University of Sydney (USYD) Campus Improvement Program 2014-2020 – State Significant Development (SSD 6123) – Submission and Objection to EIS

01 ENGINEERING - PROPOSED ENVELOPE PLAN

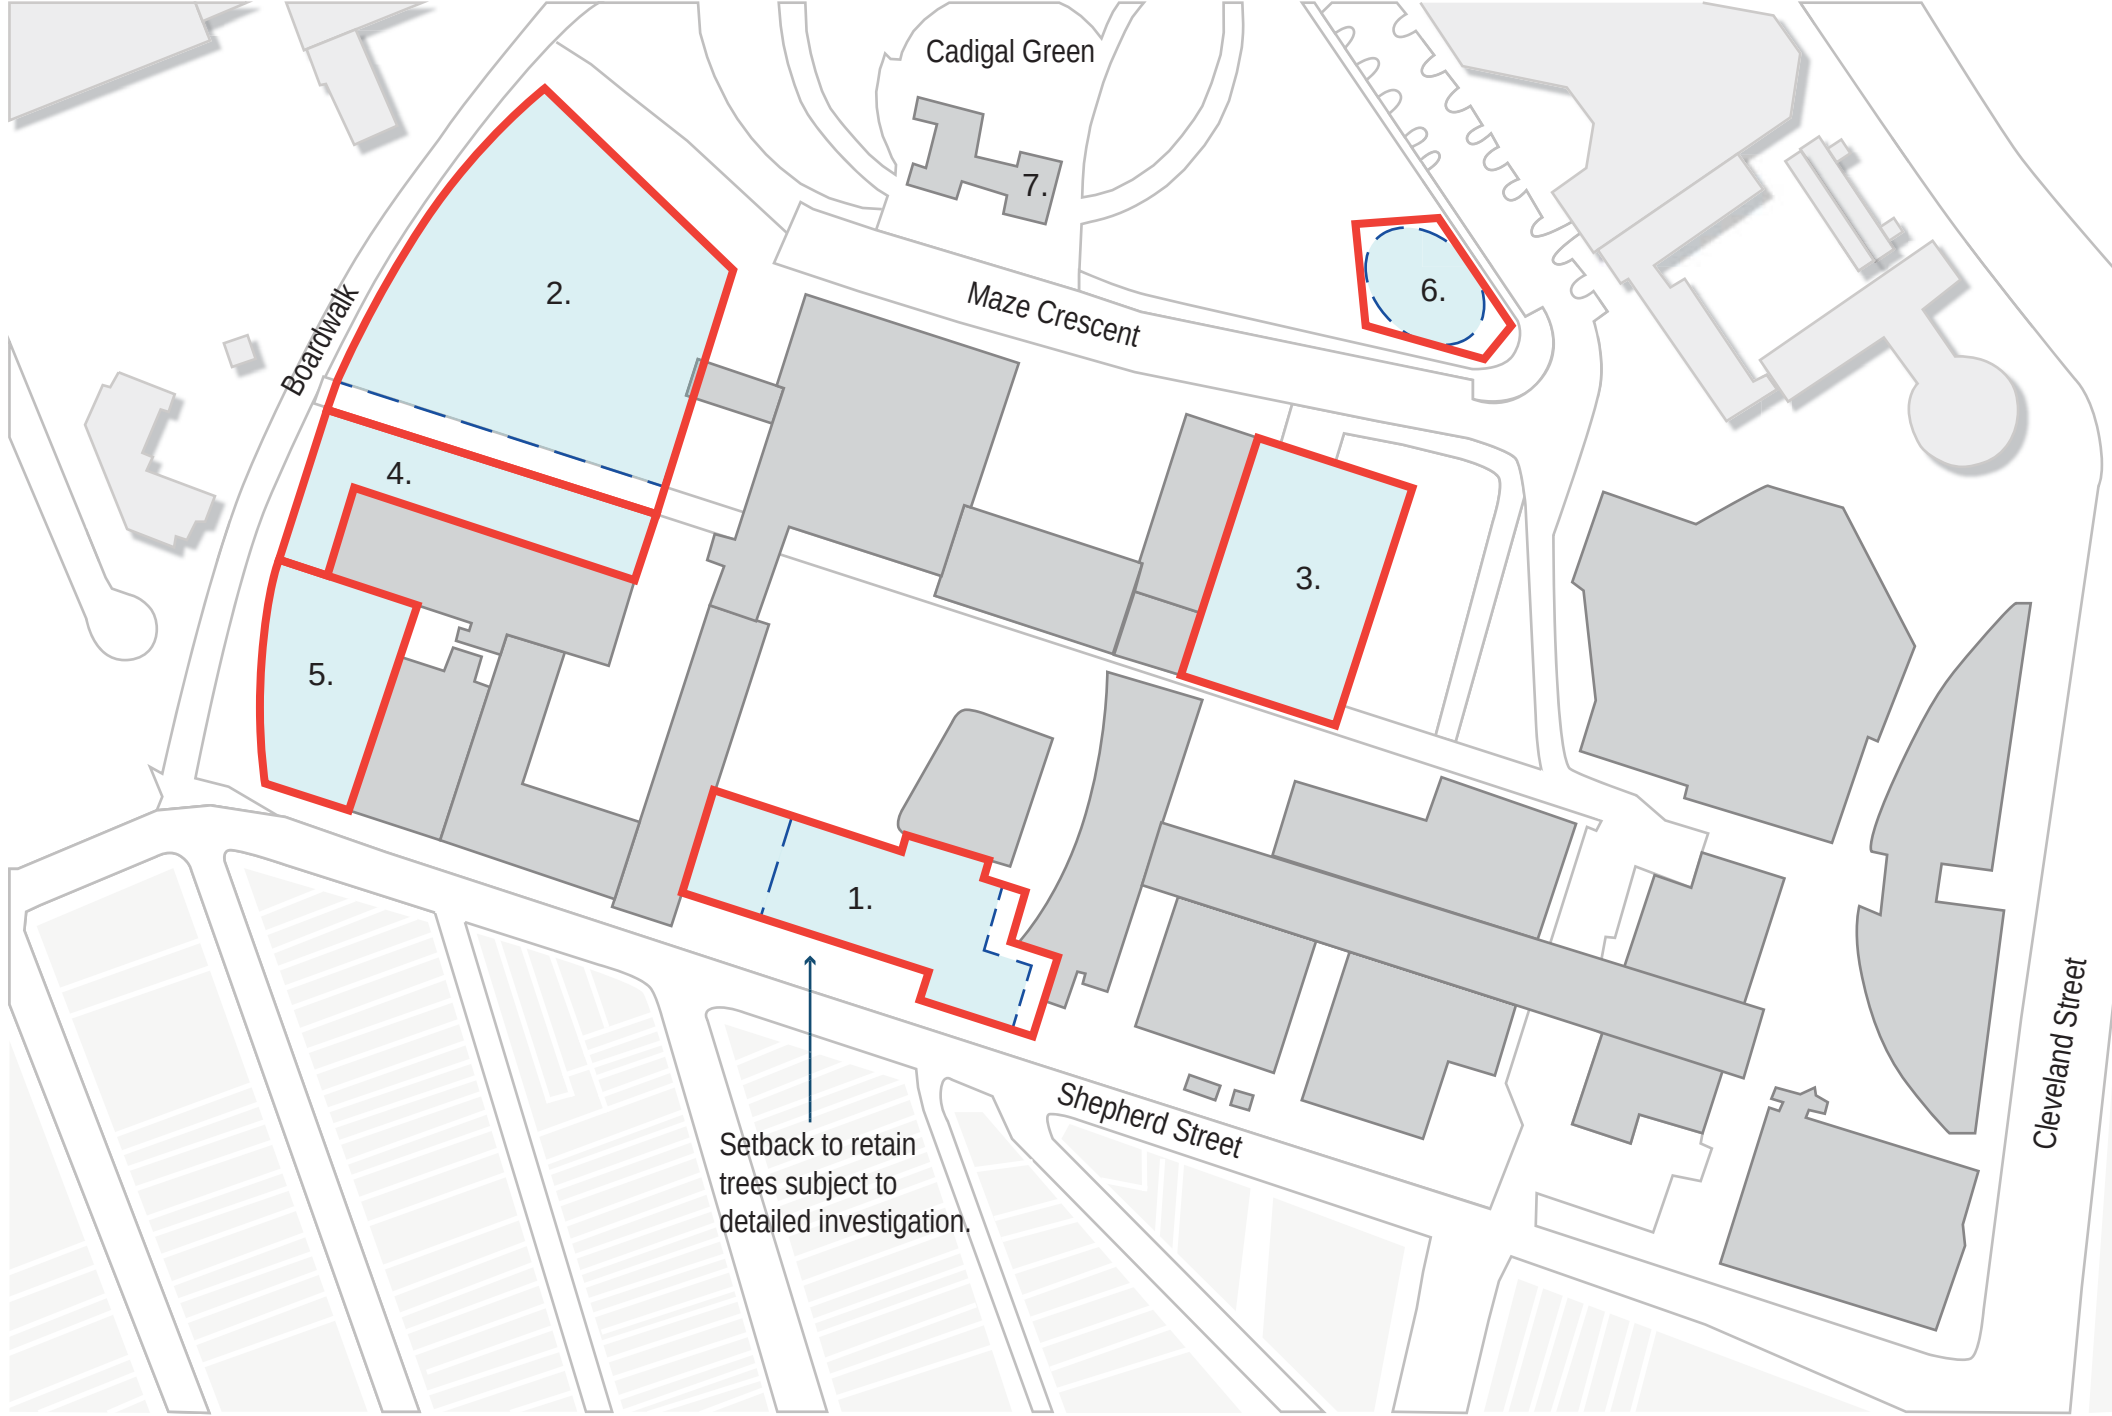
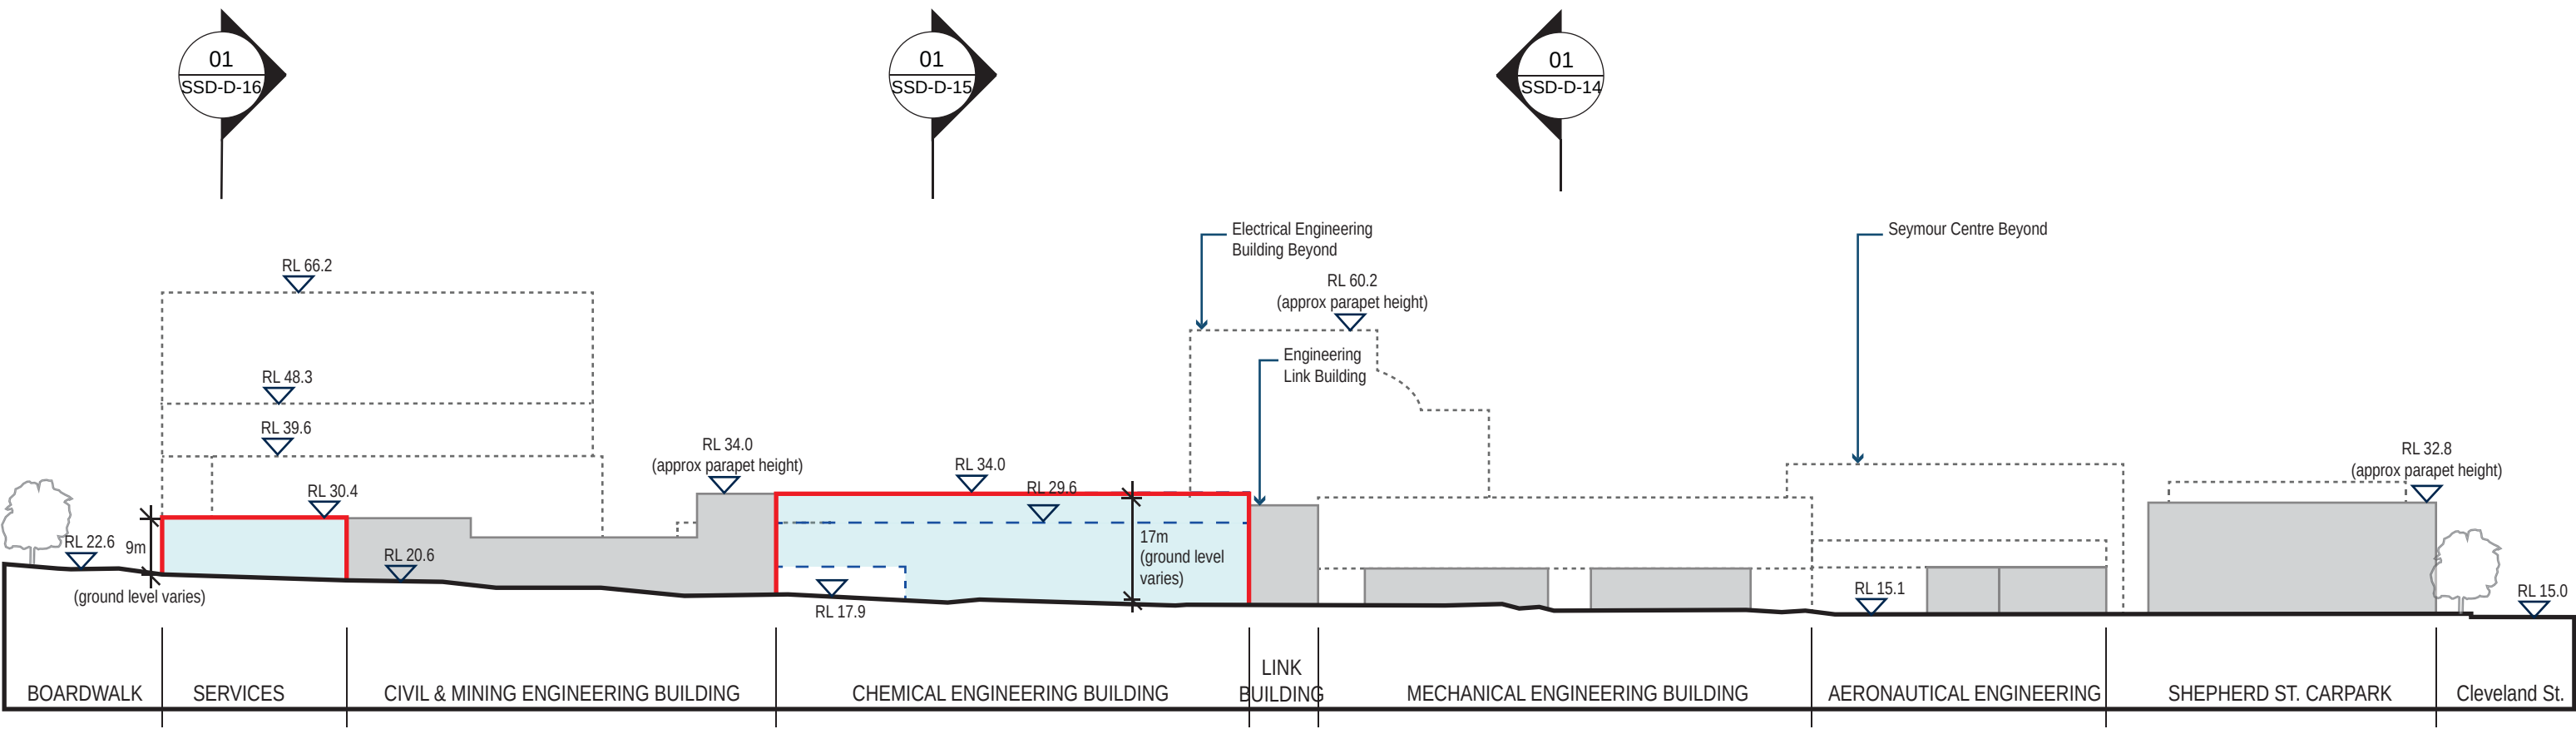
3. Increases floor area from 555,600m² to 937,800m² with building heights of up to 19 storeys. The height and bulk of the proposed buildings are too great for the low rise heritage conservation residential precinct in which the University sits. I especially object to the proposed three storey building in Shepherd Street and the "multidisciplinary building" opposite the sports centre, both of which will overlook residents homes in Shepherd Street, Calder Road, Lander Street, Boundary street and Abercrombie Street. USYD should create a green buffer zone between its buildings and all residential buildings.

01 DARLINGTON TERRACES - PROPOSED ENVELOPE PLAN

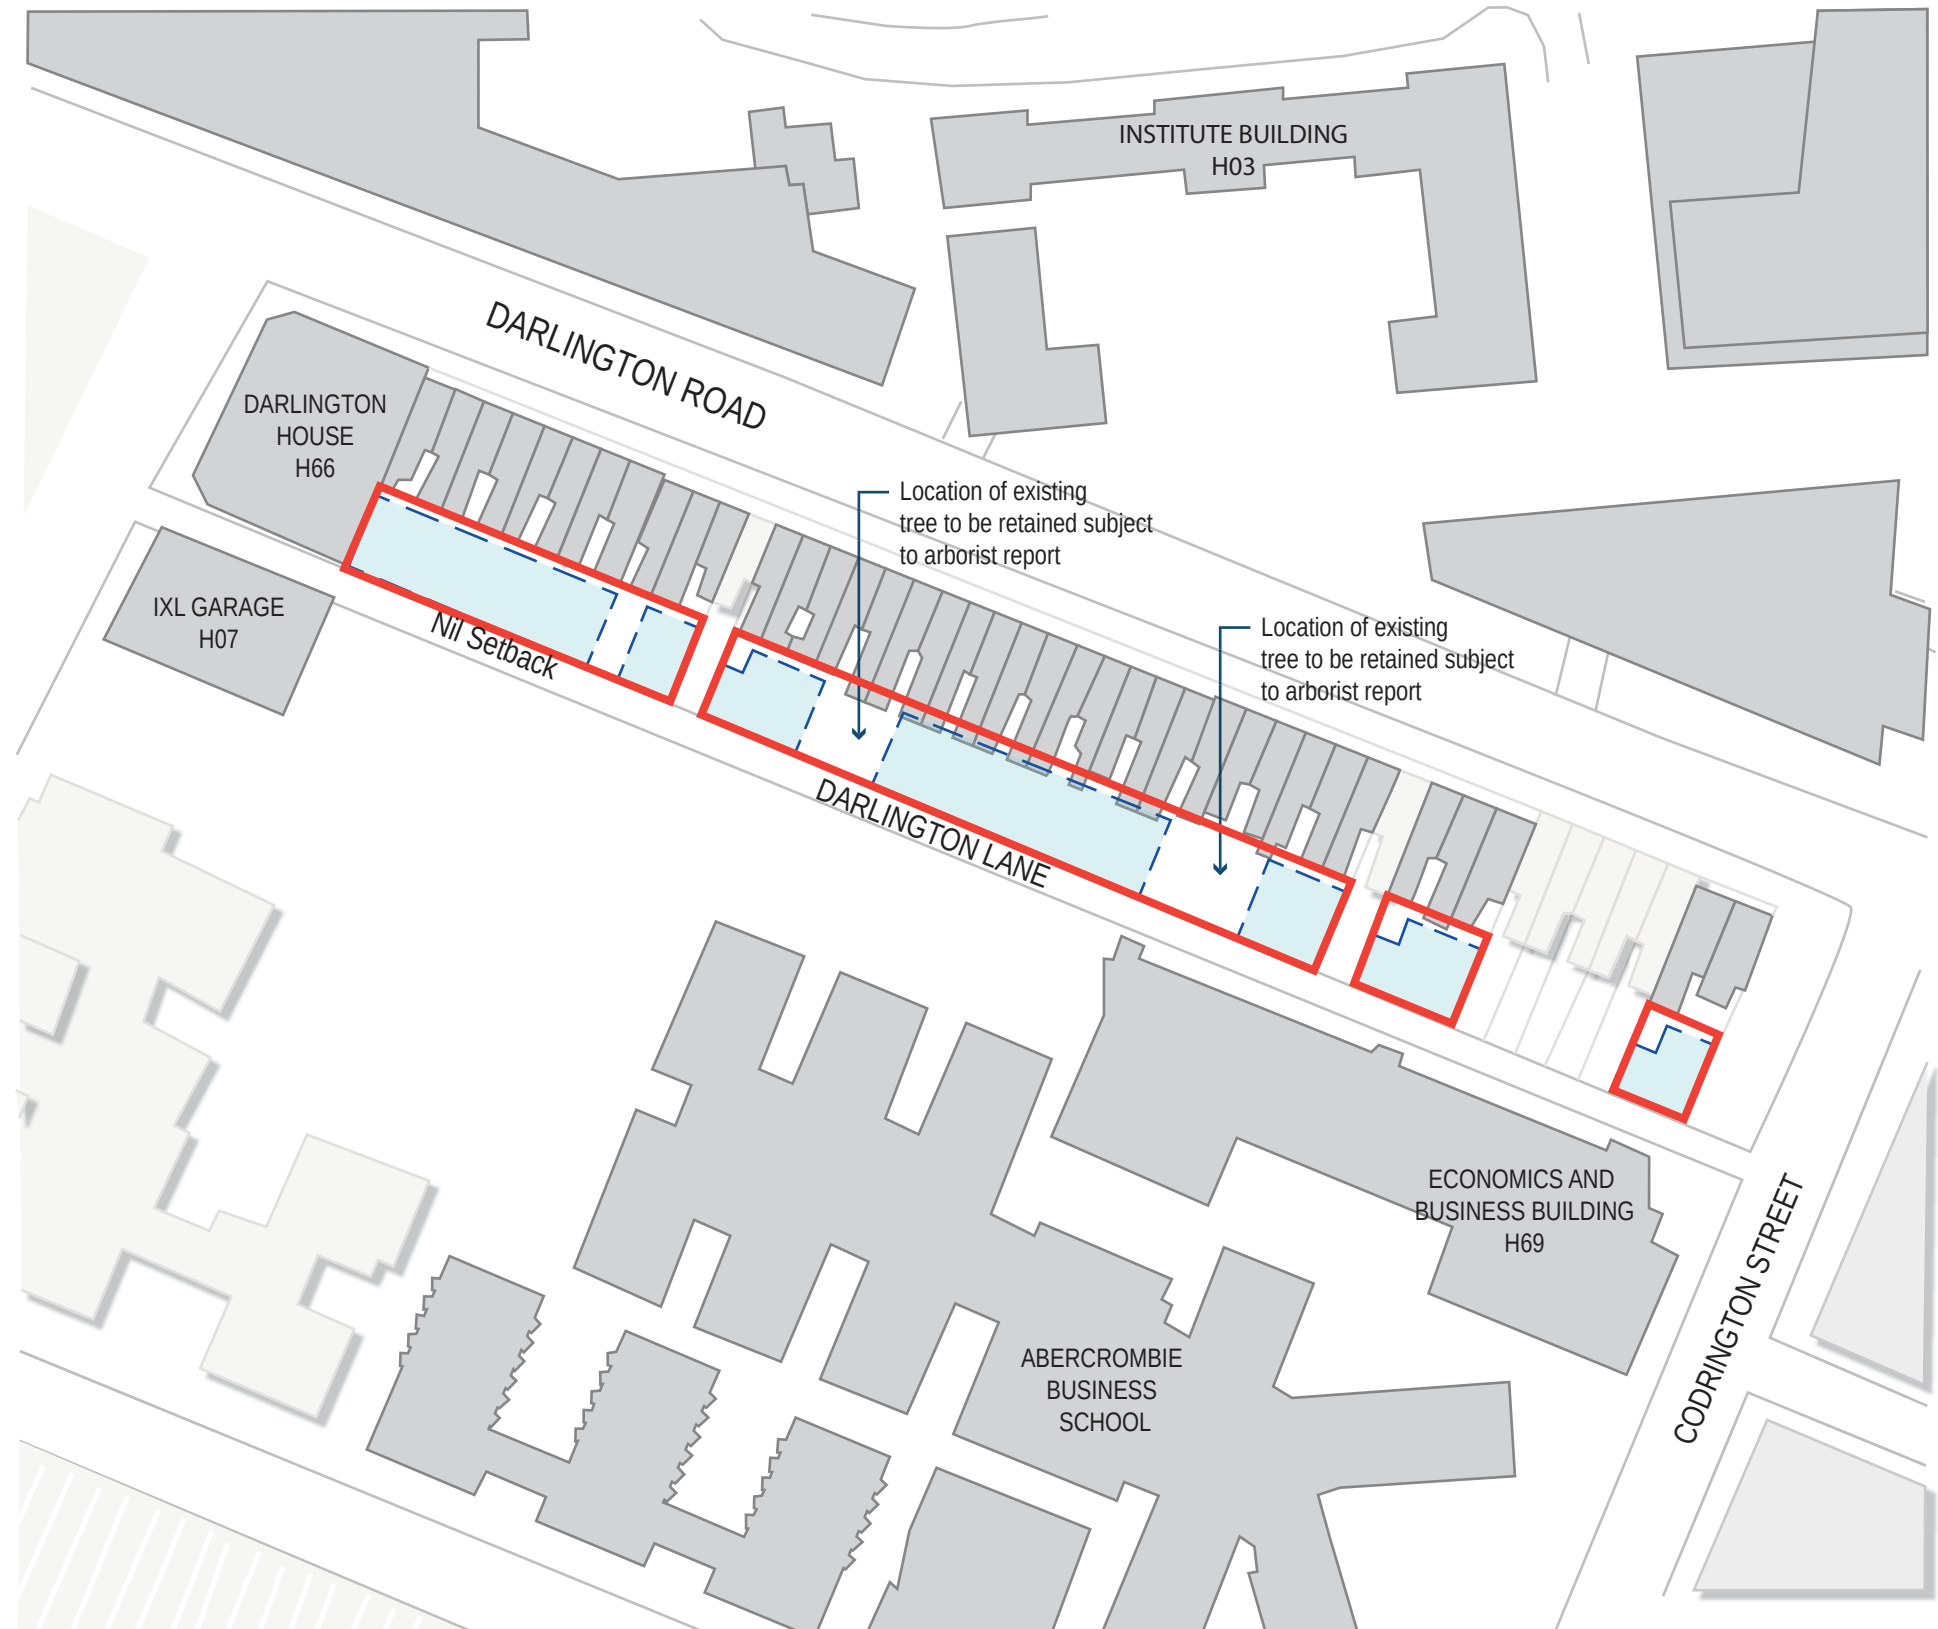
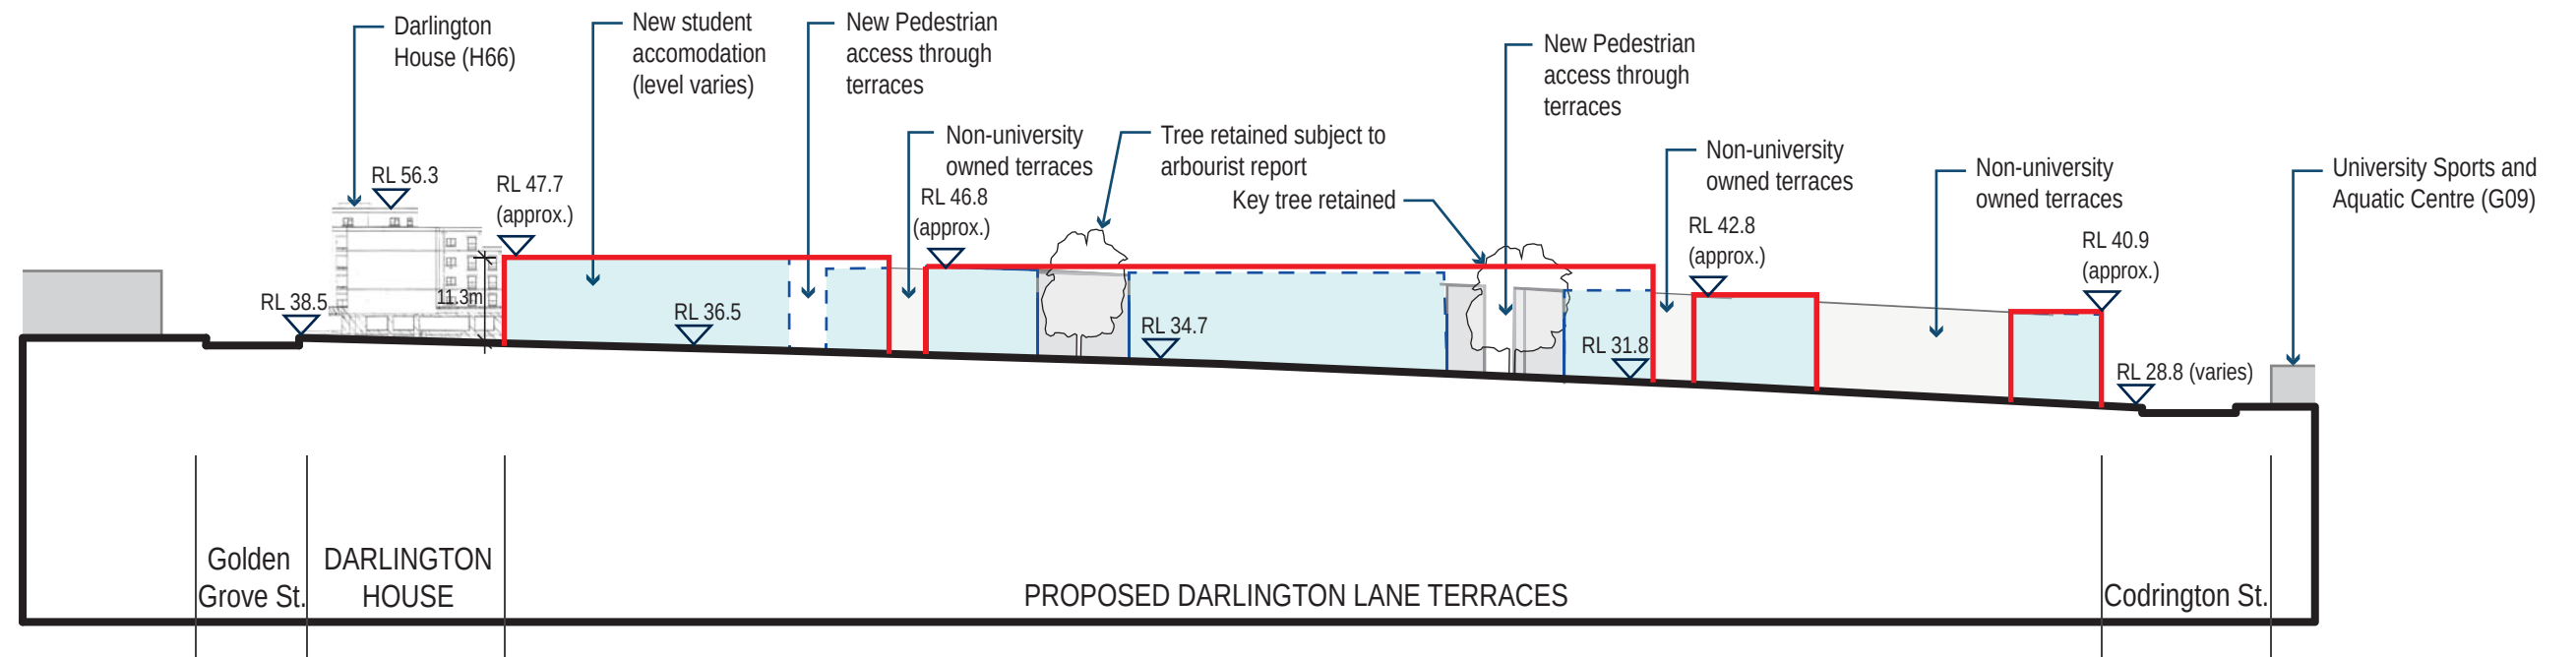
5. The proposal to completely infill the backyards of every heritage listed terrace house from 86–130 Darlington Road. The National trust has given these terraces an 'A - highly intact' rating. **USYD should not be allowed to degrade the heritage value of these terraces which are very close to the Golden Grove Conservation Area.**
